Recommendation Report for Planning Permission

REF NO: P/94/15/PL

LOCATION: Land to the east of
29 Harbour Road
Pagham

PROPOSAL: 3 No. detached bungalows with garage, parking & deck (resubmission following P/12/15/PL)

STREET SCENE — Harbour Road.
with levels (A.O.D.)
Scale 1:100

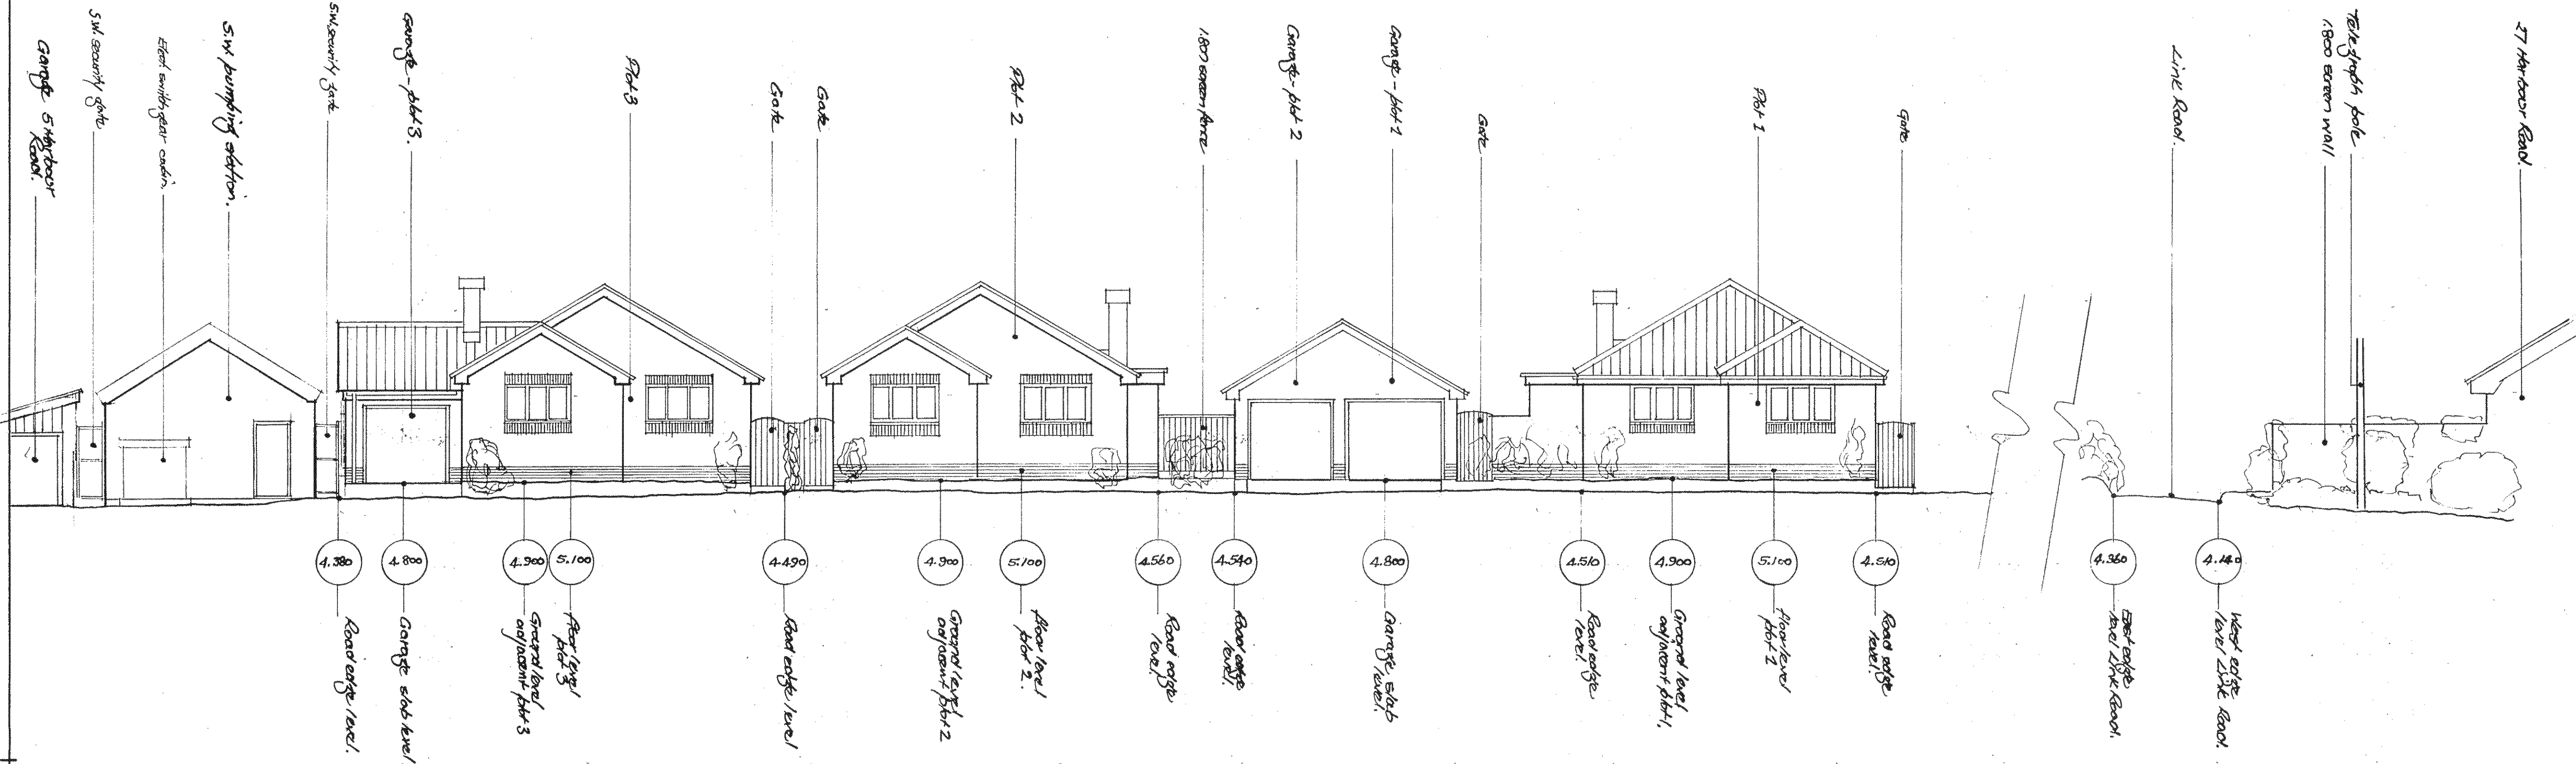
In order to mitigate the development against the impact of flooding, the properties are raised a considerable height above the existing ground floor level. As a result the properties would have a significant impact upon the street-scene and the local area, particularly when viewed in comparison with the yacht club buildings and properties to the immediate south and west".

The Council's Conservation Officer raises concern that the proposal will (a) result in the partial loss of an existing open space, (b) introduces dwellings that are not unique enough to contribute to the ASC and (c) has an adverse impact on the streetscene by reason of raised floor levels.

It is considered that the proposed development is contrary to the ASC policy with regard to its poor design and the partial loss of the yacht club open space. However, the submitted streetscene demonstrates that the act of raising the floor levels has only a slight impact on the streetscene and that the bungalows will not be significantly higher than the adjacent pumping station building.

Location Plan

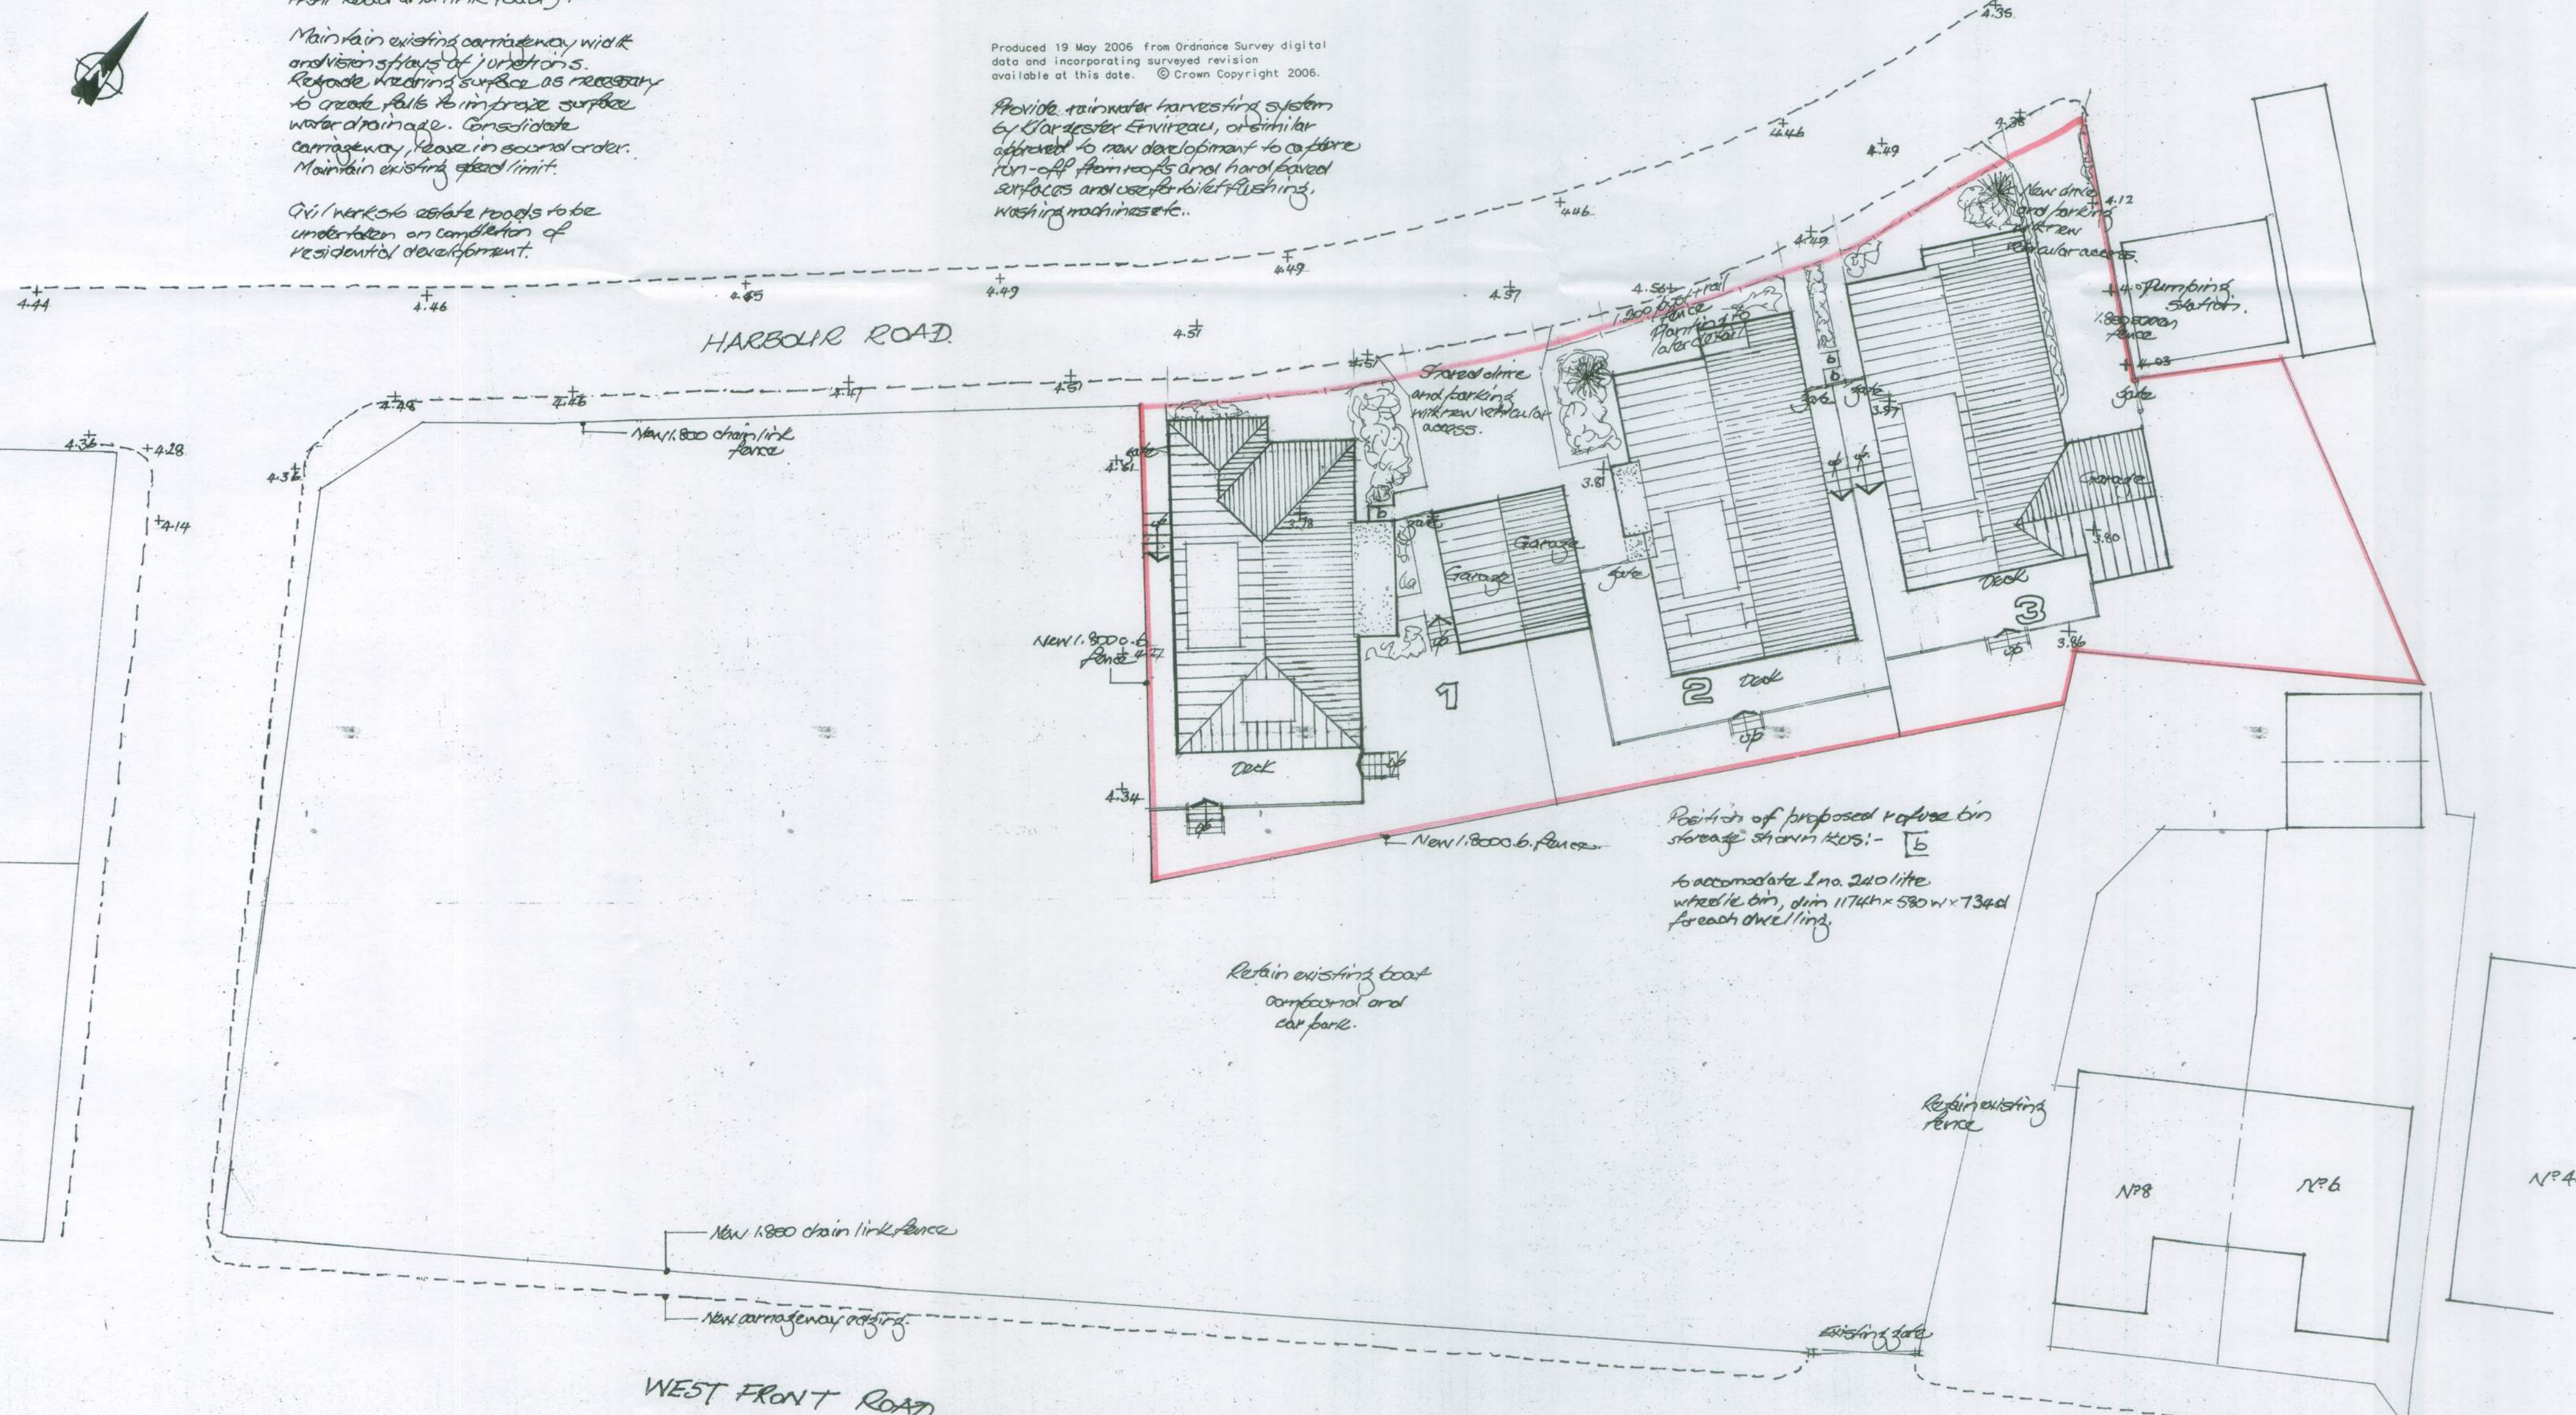
SOUTHERN WATER - Objection. Southern Water object to the layout. They state that due to the vibration, noise and potential odour generated by sewage pumping stations, no habitable rooms should be located closer than 15m to the boundary of the pumping station site. Southern Water also request conditions to (a) approve the details of the proposed rainwater harvesting system & (b) to seek details of the proposed foul & surface water sewer schemes, and an informative regarding connections to the foul sewer.

The site lies adjacent to an existing Southern Water Pumping Station. Southern Water best practice is not to allow any new habitable rooms within 15m of the boundary of a pumping station. The whole of plot 3 and part of plot 2 fall within this 15m buffer distance. Council Environmental Health officers also consider that there is potential for the new dwellings to be adversely affected by noise emanating from the pumping station. Information has been provided by the applicant but none of this has been of a sufficient standard to allow the proper assessment to be made. Without such information, there is no way to rule out the potential for adverse effects to residential amenity and therefore, the application has to be considered contrary to Policy GEN32.
